Application No: A/80/22/CLP
Site Address: Rear of 40 and 88 Meadowside Angmering BN16 4BN
Description of works: Lawful development certificate for the proposed erection of 11 No garages that was granted under A/32/64.

Thank you for your internet representation made on 12th May 2022 which has been recorded as an objection with the comments as follows:

Figure 2 - Approved 11no. Garages Location

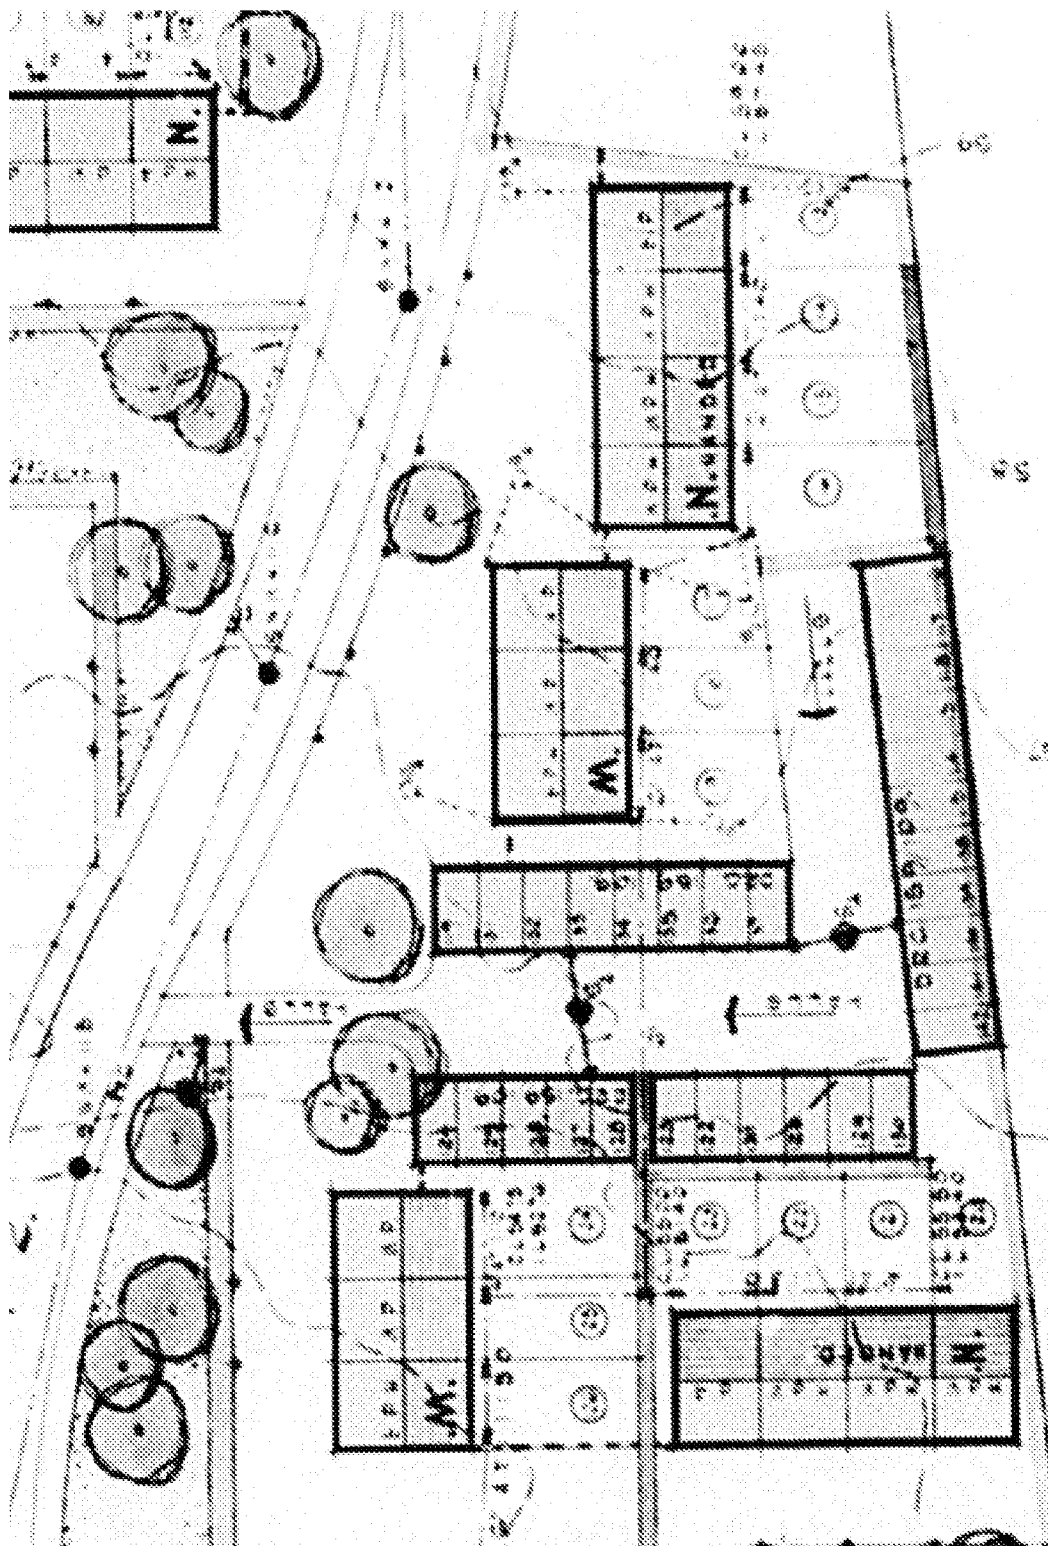
The size of vehicles today compared with those of 60 years ago is much larger and will not fit comfortably in garages designed in the 1960's, thereby rendering use of these new garages as useless for their intended purpose of car parking.

Appears to be a lack of consideration for the footpath in the far NE corner of the site which gives access to the properties along that footpath and will also make it difficult for use by any disabled vehicles etc. and the back entrance to the property in the SE corner of the site

GREENACRES, ANGMERING, Sx.
SINGLE DOUBLE AND MULTIPLE
GARAGES.

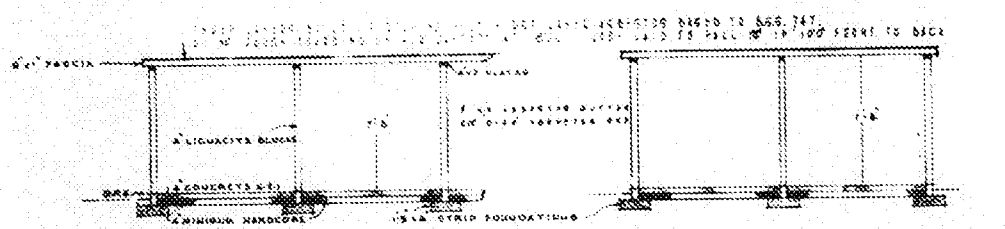
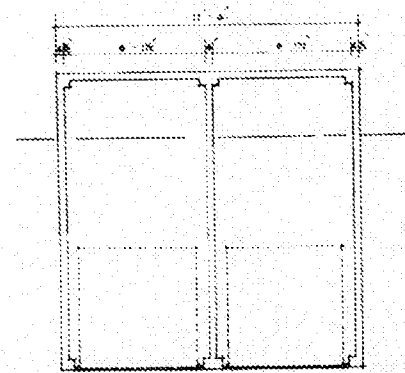
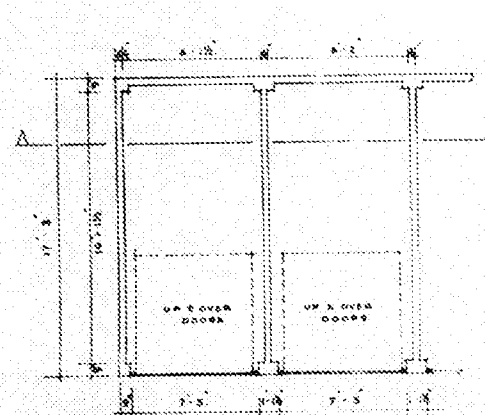
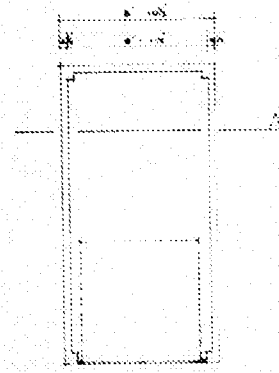
Insufficient up-to-date paperwork regarding plans, design, and materials.
